23 Ocean COA second submission

Subject: 23 Ocean COA second submission

Site Plan Conditions of Approval

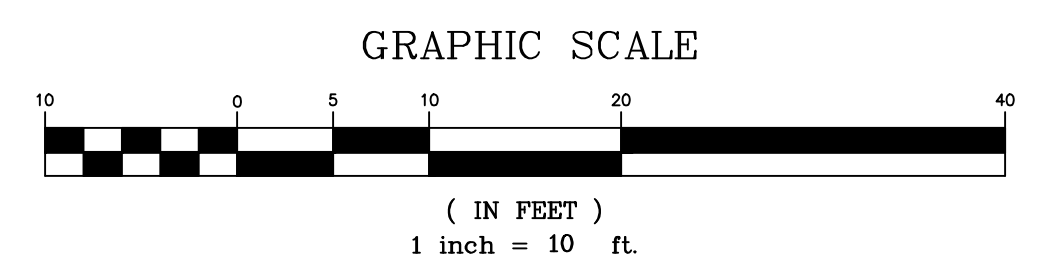
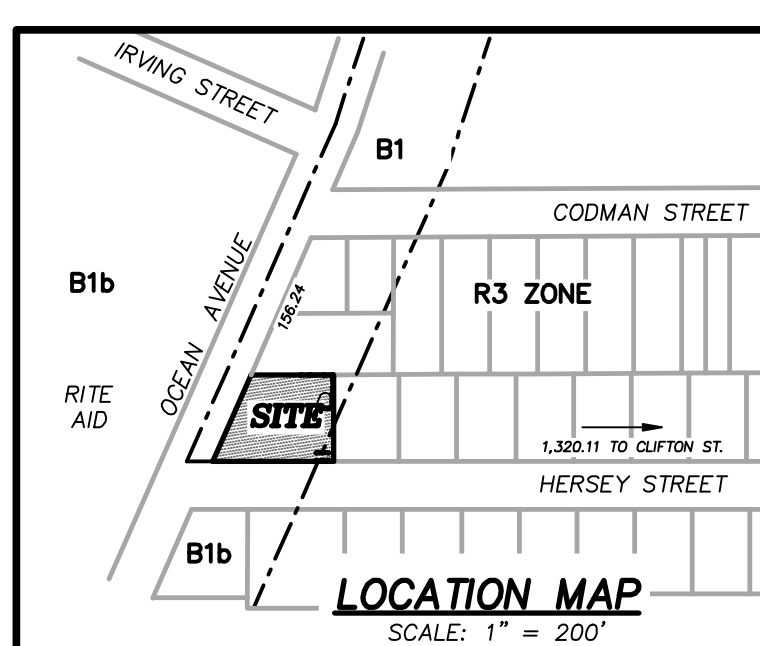
1. Plat

DPW reviewed plat and has no comments. My comments on the plat are attached.

Revised plat attached.

**L-2.0**

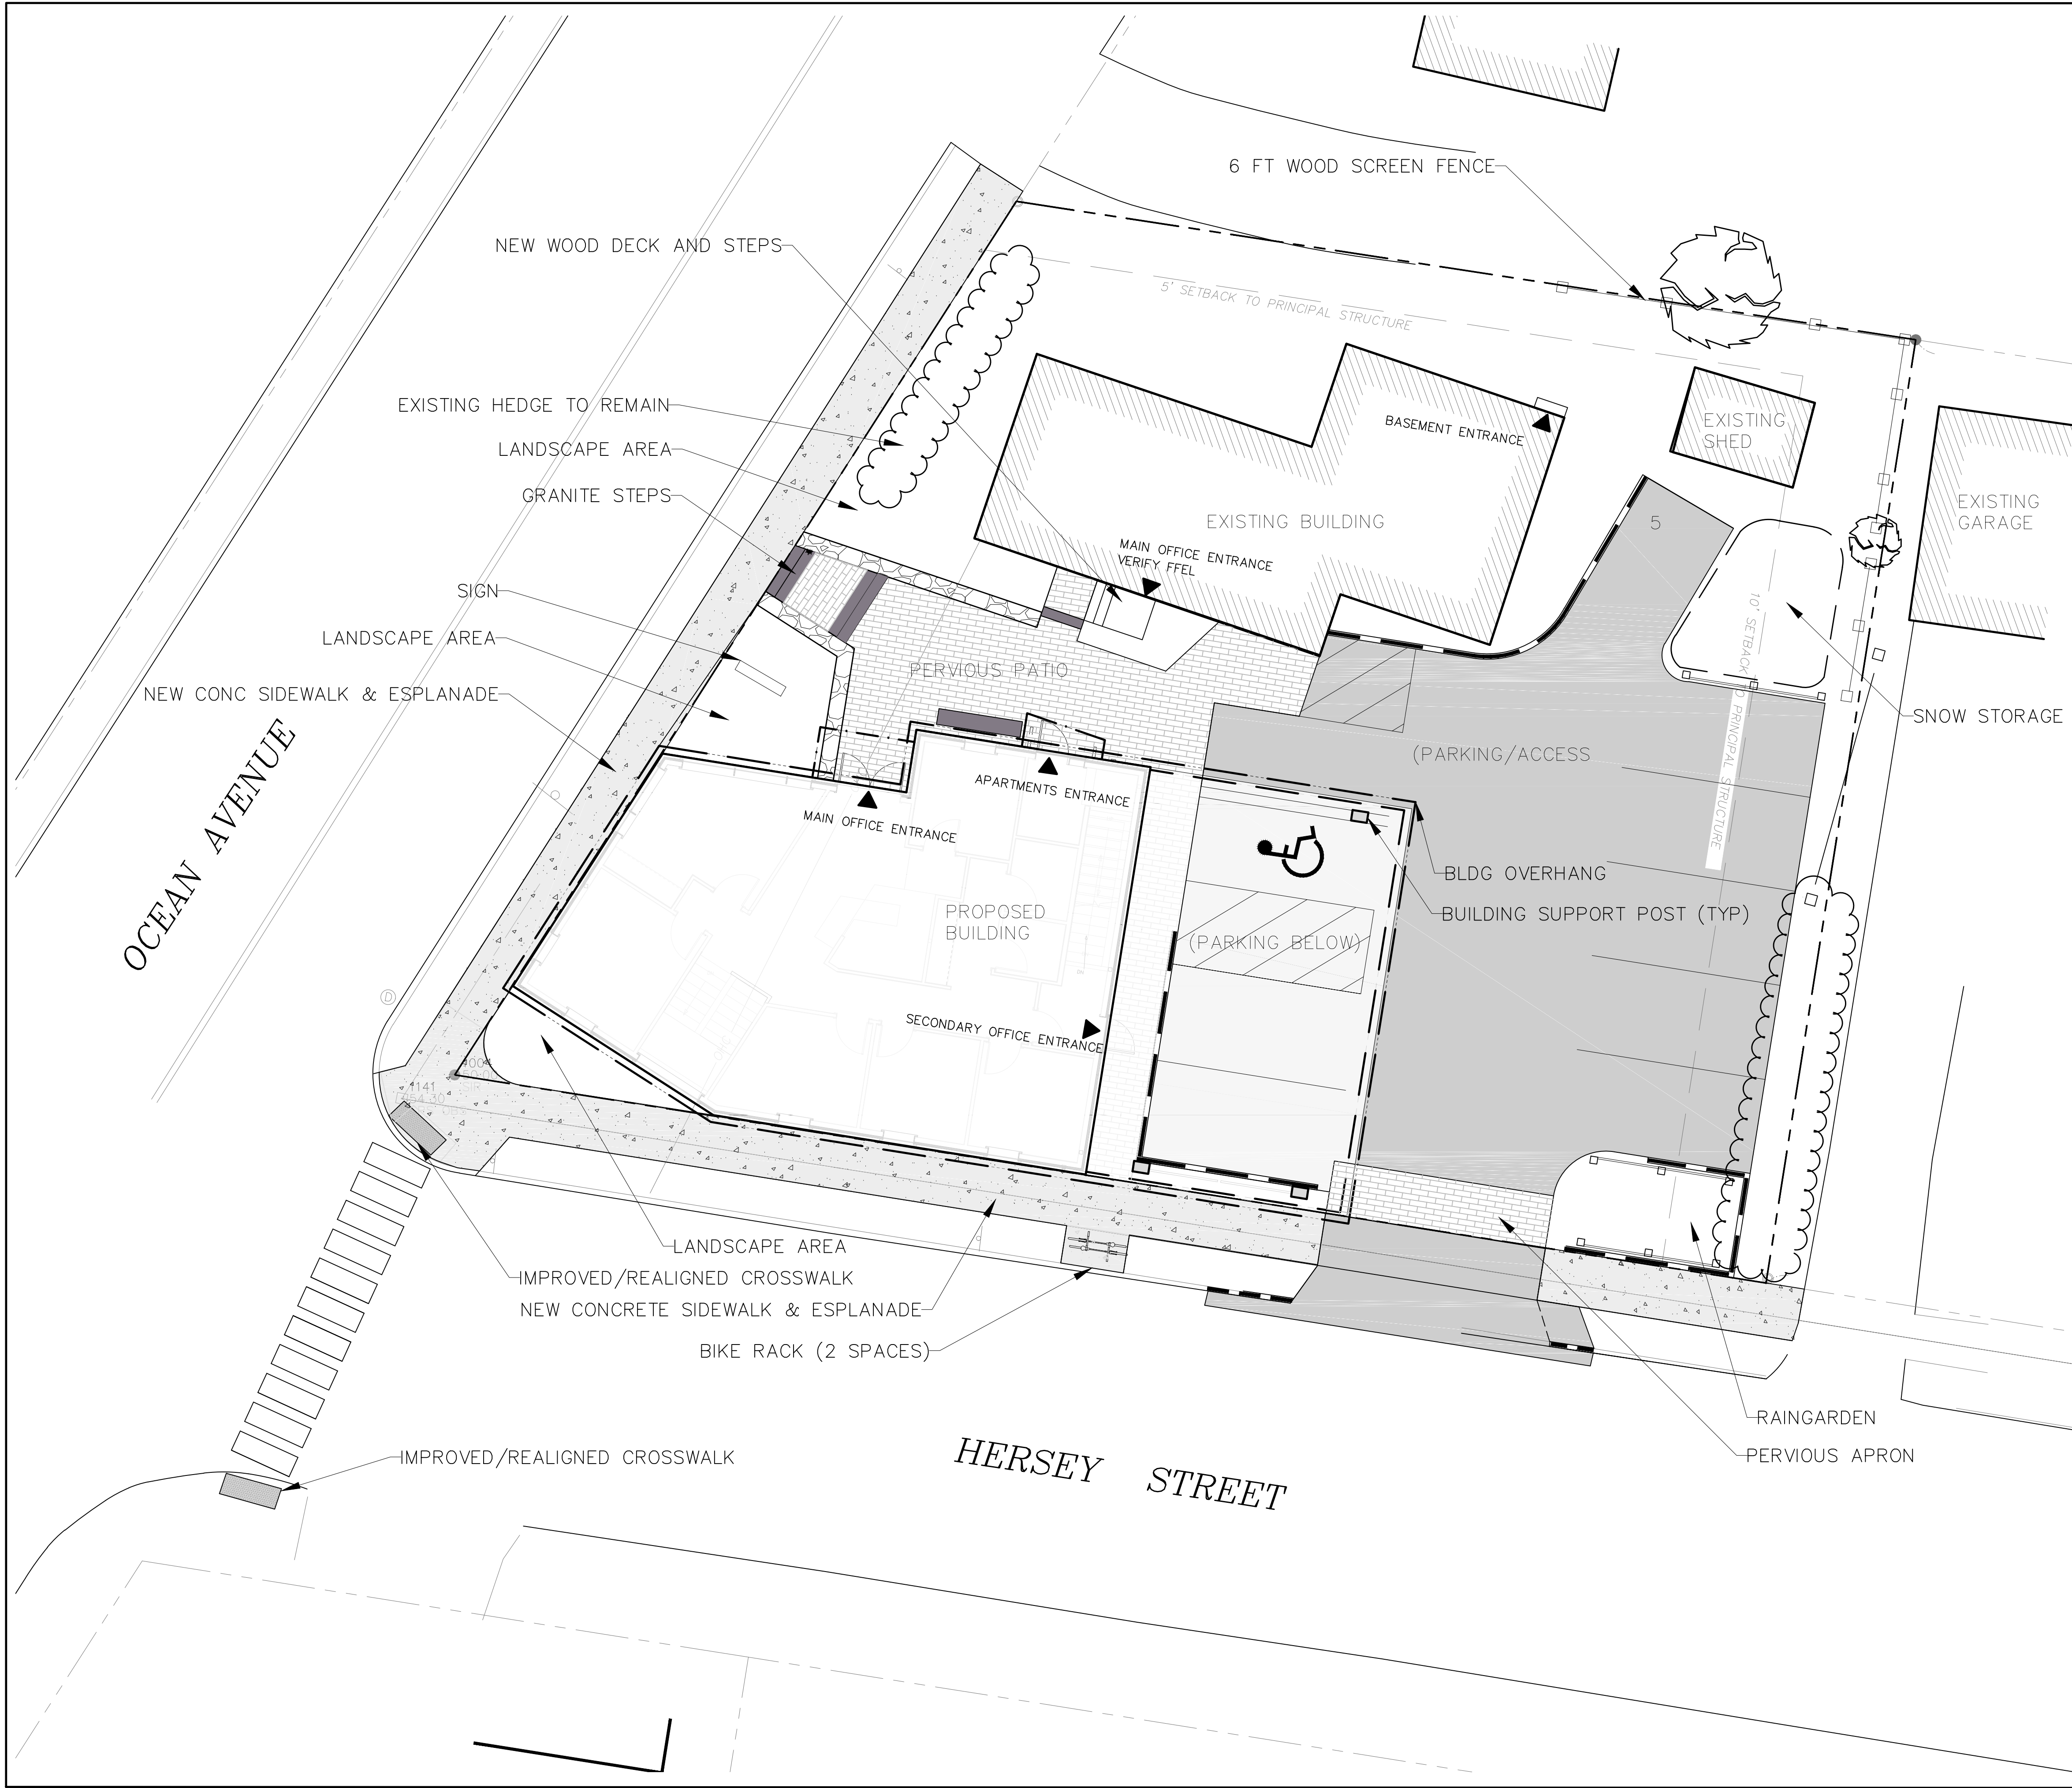
6. Snow storage

- | | 1. Shown on sheet L2.0 included in the zip file.

Condition met.

Job Number:
File:
Date: 09-02-2016 **Scale:** AS SHOWN
Drawing Number:
L-6.0
© 2016 CARROLL ASSOCIATES

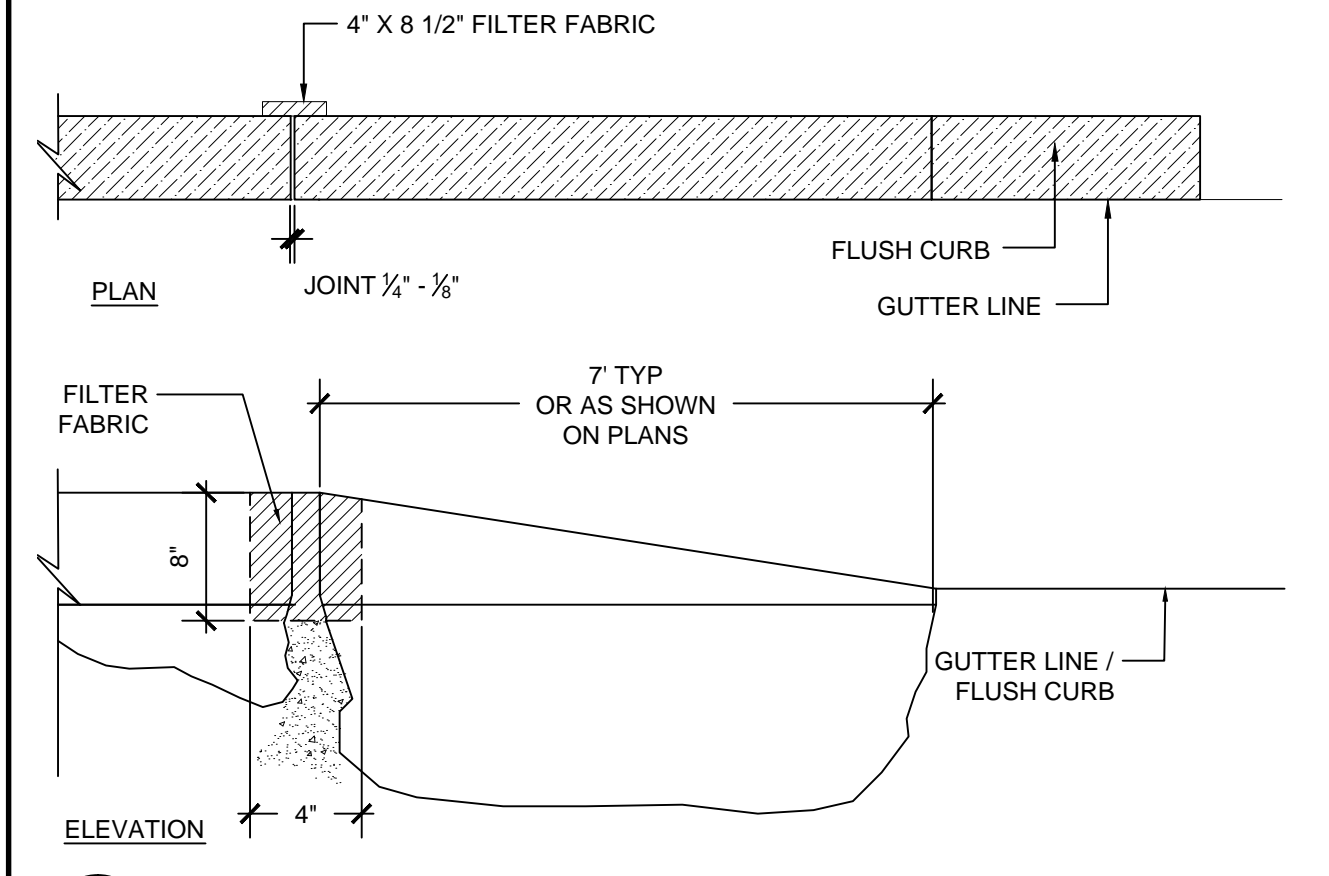
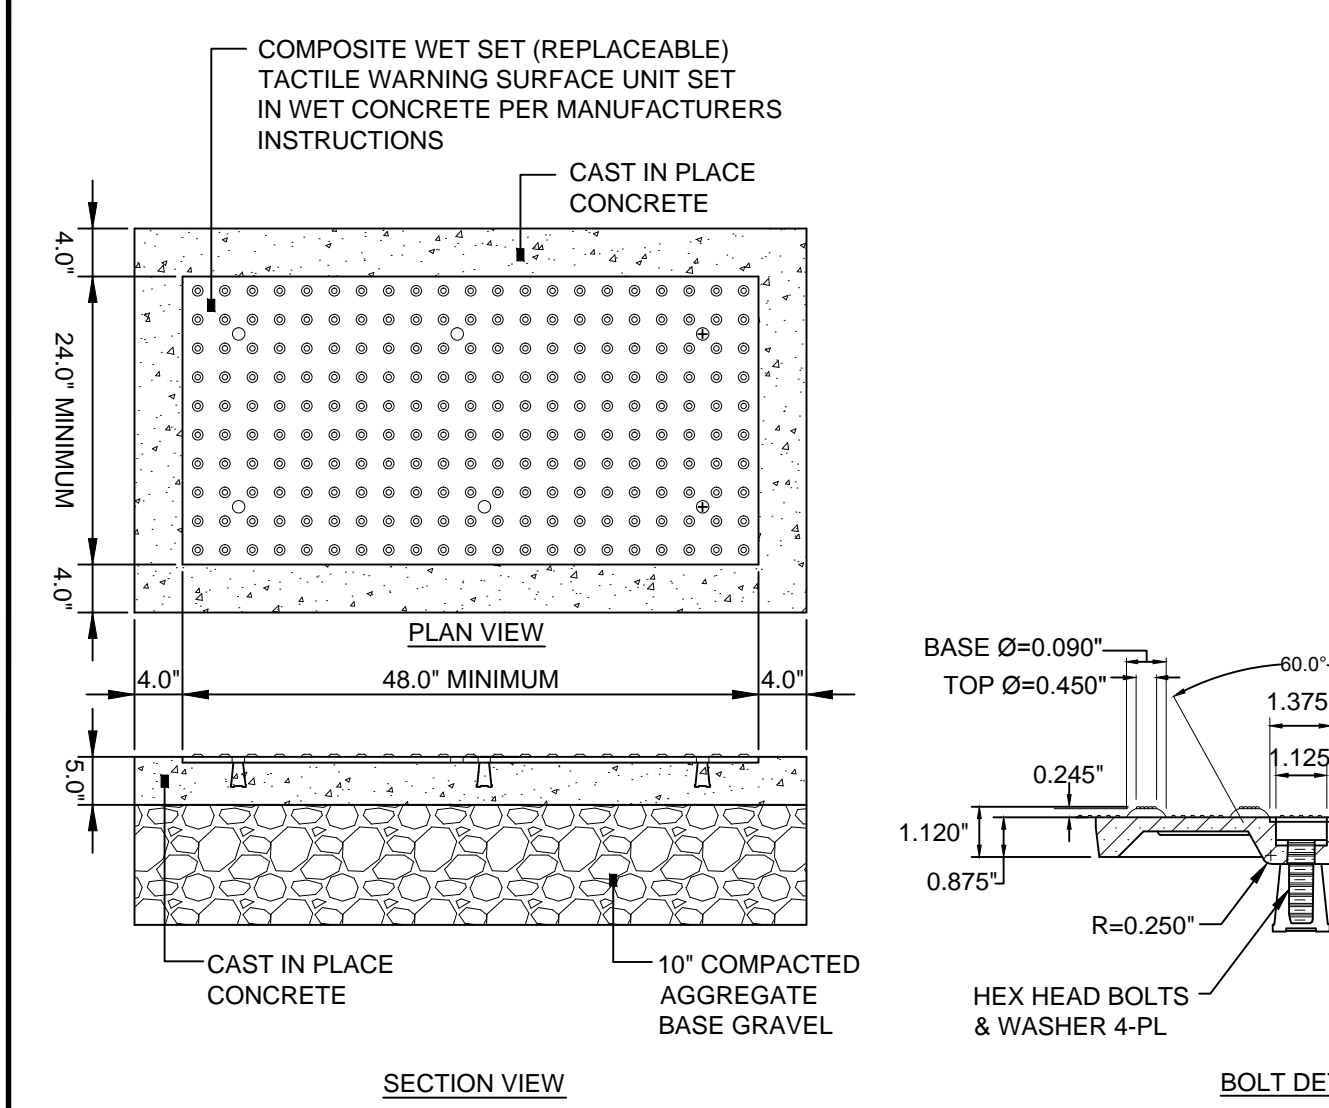
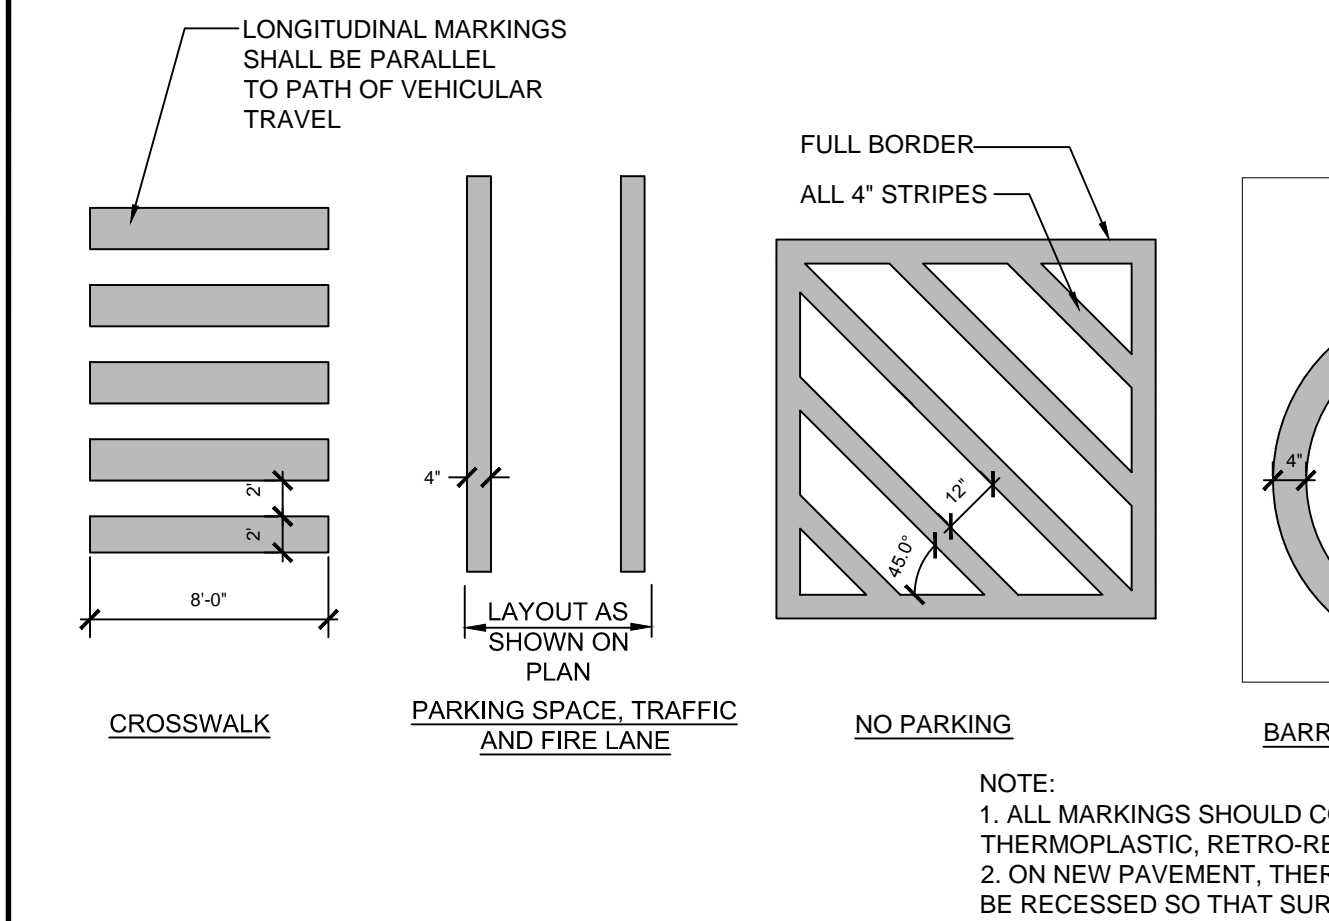
2. Details for Hersey Street ramp.

TE's comments on ramp design attached. John should feel free to be in touch with Tom if he has questions.

- | | 1. Shown on sheets L2.0, L3.0, L4.0, and L6.0 included in the zip file.

John has visited the site and conferred with Tom Erico to confirm the design. Landscape drawings attached incorporate the design as reviewed with Tom.
